# THE GLEN WIDFIELD - POA ANNUA INTERSECTION

## EL PASO COUNTY, CO

DESIGN CALCULATIONS

Kiowa Engineering Corporation  
Date: July 19, 2022

Profile View of Storm Lateral 'J' - Pond Inflow

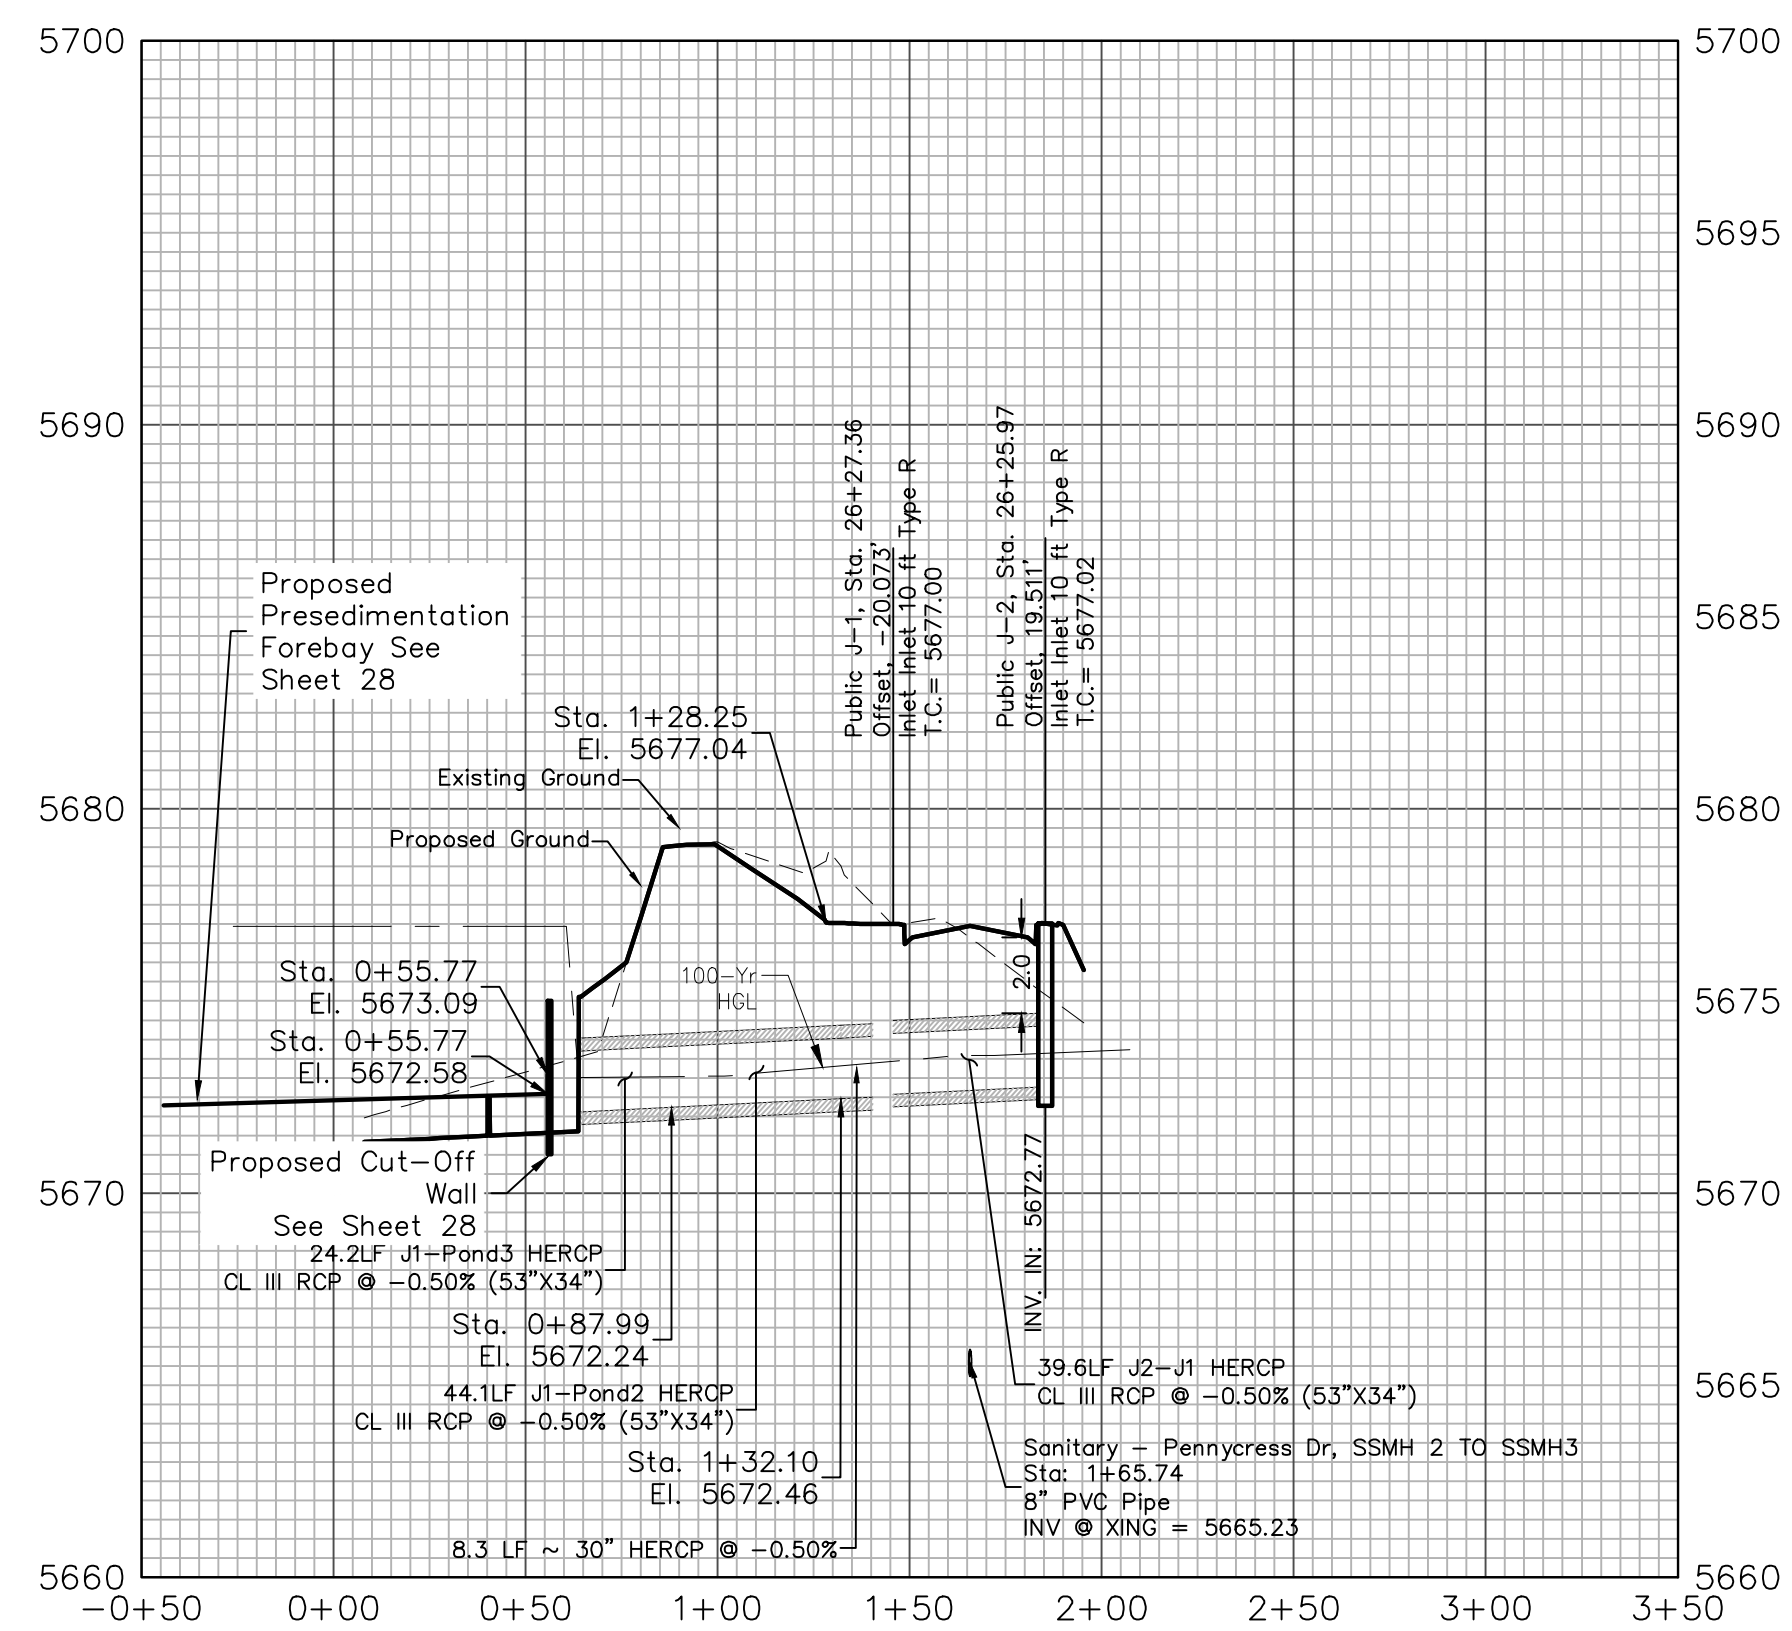
- No Exception Taken
  - Rejected
  - Submit Specified Item
  - Make Corrections Noted
  - Revise and Resubmit
- We are verifying with the County that the note on the Poa Annu profile (sheet 21) has been addressed.*
